NSIP Reference Name / Code: Keadby Next Generation Power Station EN0110001

Natural England's Written Representations

Figure 8B3.2 Trends in Nitrogen deposition Risby Warren

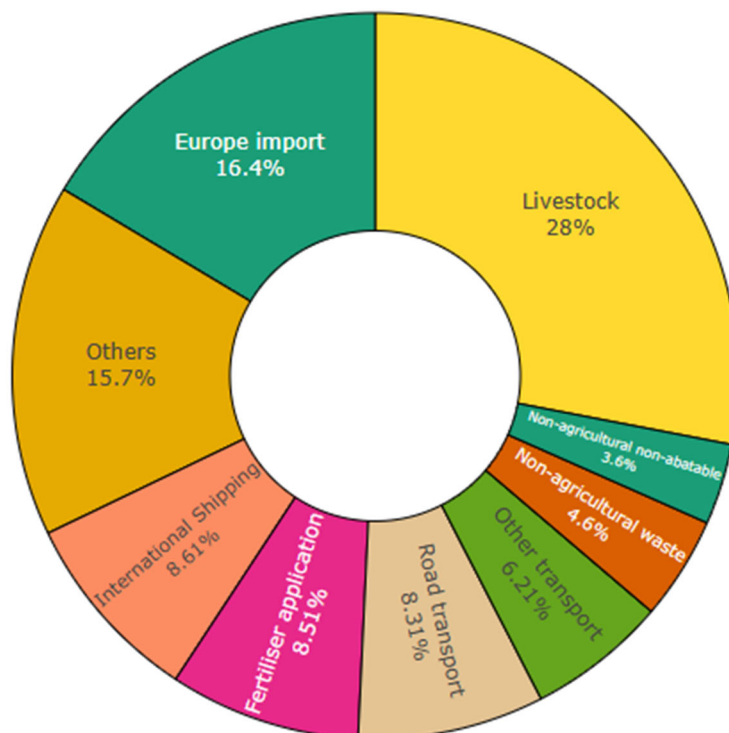
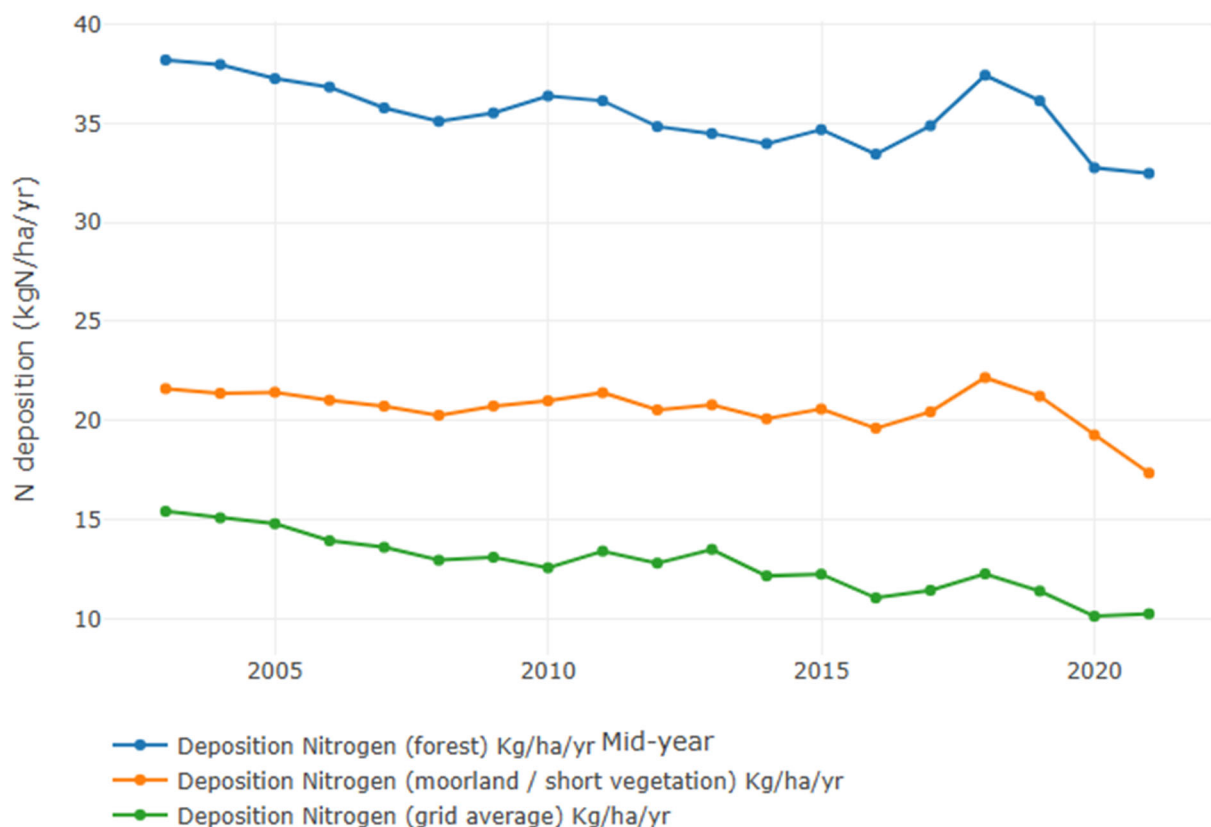
<p><i>Assessment of Risby Warren SSSI Ndep</i> – The assessment of the impact at Risby Warren SSSI is not considered to justify that there will not be harm arising. Adding additional Ndep onto an already exceeding site will not allow recovery of the designated features (lichen heath/ acid grassland). (11.7.113 indicates that elements of the qualifying feature (lichen heath) of particular sensitivity to nitrogen deposition have already been lost due to the existing baseline load – indicating that adding more will take the site further from recovery). If harm cannot be excluded (including in-combination with other plans or projects), consideration of additional mitigation could be taken into account – such as ensuring emissions of N pollutants are kept below a set amount through decreased ELVs or reduced consented hours (as suggested at 8B.5.35).</p>		
NE21	Water Quality - Boat Movements (C)	<p>HRA 6.2.54. We advise that the measures taken to avoid or mitigate pollution of the water environment from boat traffic and unloading of cargo will need to be considered when applying for a license from the navigation authority.</p>	N/A	Grey
